**From:** Jeff Tarling<JST@portlandmaine.gov> (Jeff Tarling)  
**To:** Helen Donaldson  
**CC:** David Margolis-Pineo  
**Date:** 1/27/2016 12:32 PM  
**Subject:** Landscape Review for 65 Munjoy project

I have reviewed the landscape plan and offer the following suggestions / conditions : (The Rain Garden should have plant labels to the plant graphic so we can find them when we do the final inspection)

**RAIN GARDEN DETAIL**  
NOT TO SCALE

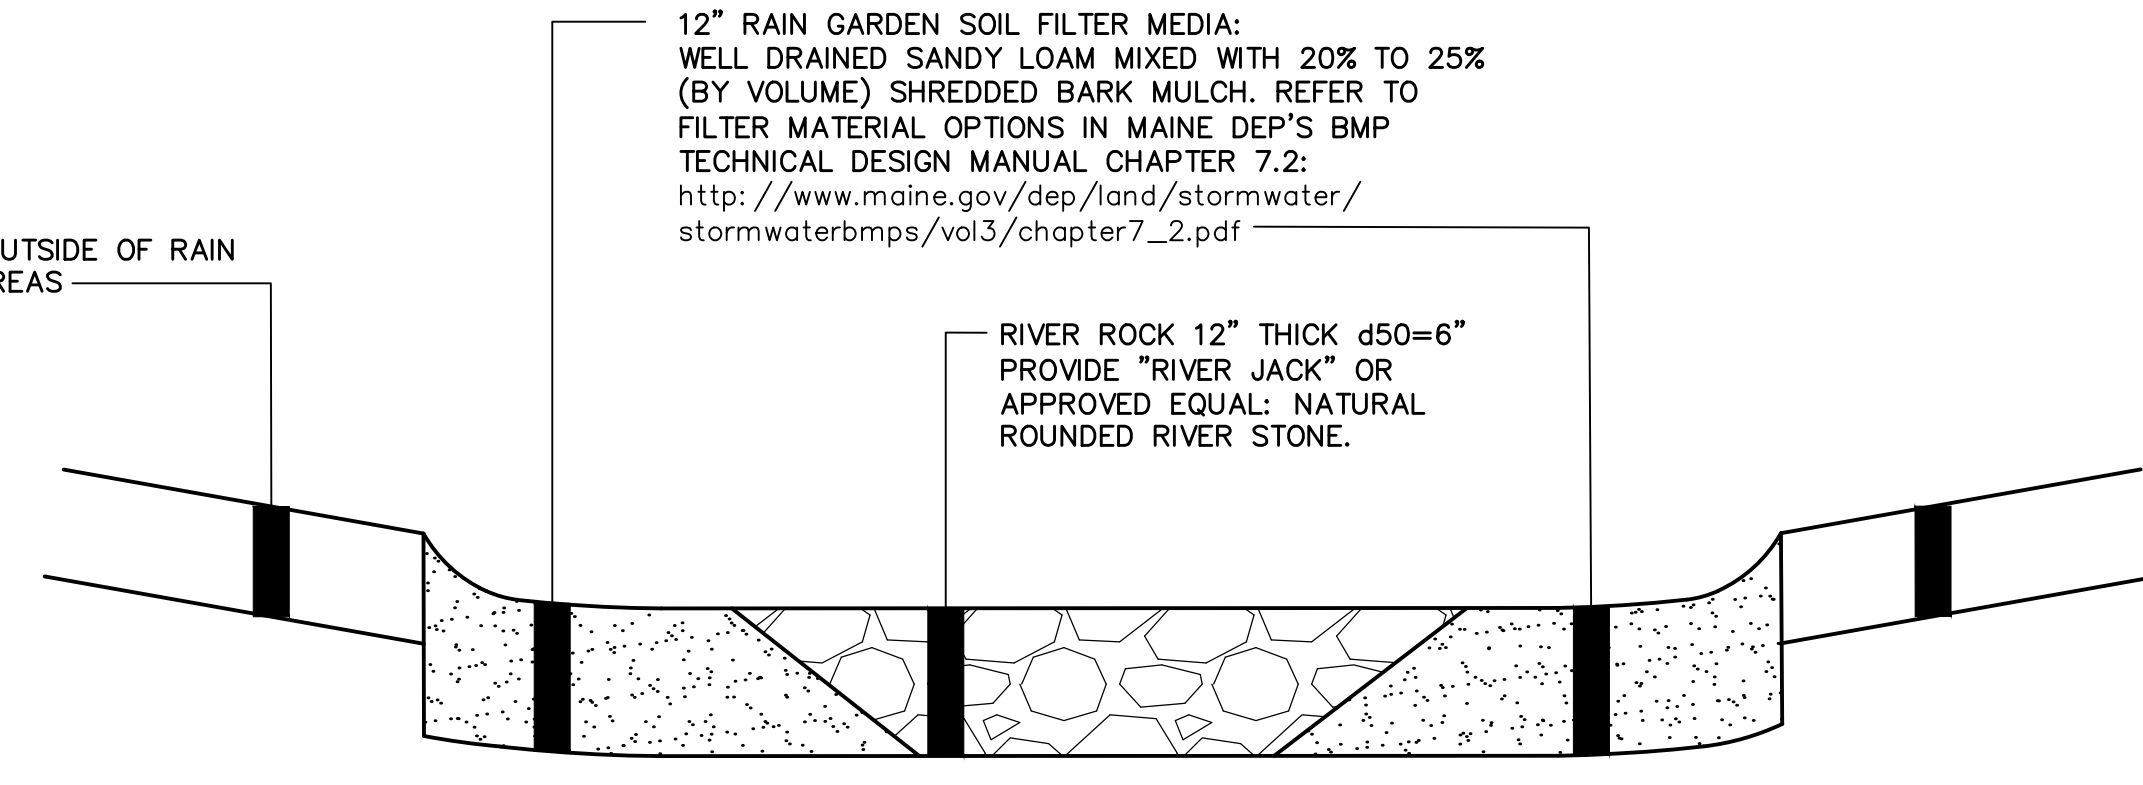
**c) Rain Garden** - As mentioned above, plant names should show where plants are located. Caution on the use of 'Red Twig' knowing their expanding size, might be worth looking at 'Kelsey Dwarf' or other low growing types to better fit this space.
